From: Zac Denton
Sent: 22 December 2020 15:00
To: Planning Scanning
Subject: FW: R/226/20/DOC

Woodbine Cottage 1 Mill Lane Rustington BN16 3ED

Approval of details reserved by condition imposed under ref R/93/20/HH relating to Condition No 3 - materials to be used for fenestration (including rooflight).

Side Window

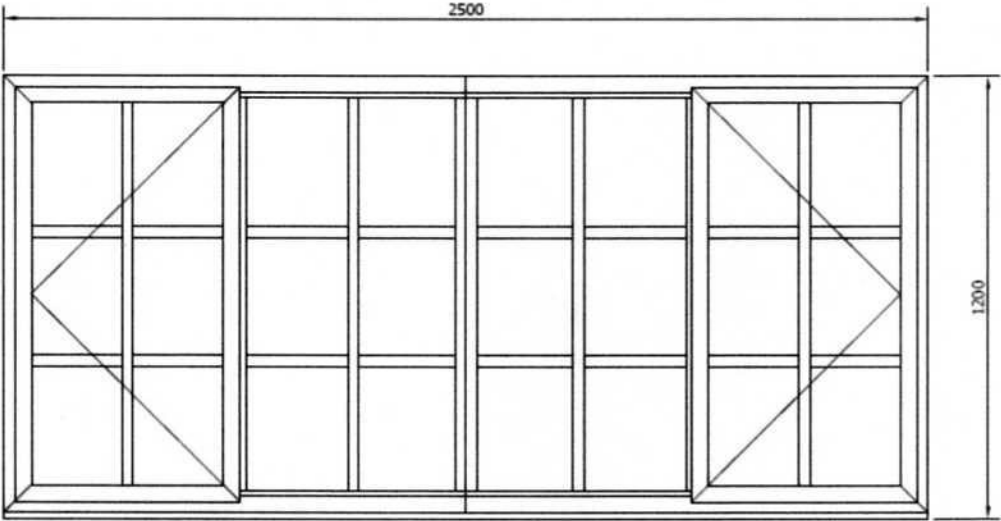
Front Window: It is not clear from the information provided what the glazing system will be. If it is to be double glazed, will the slimmer units be used? I should point out that as the proposal affects a modern extension, the use of the slimmer units would be acceptable. Further, as the application only provides a front elevation drawing of the casement window it is not clear what the glazing bars etc will look like, or what their dimensions will be. This information can be provided in the form of a drawing which shows the section of the window and includes details of the proposed glazing and appropriate measurements.
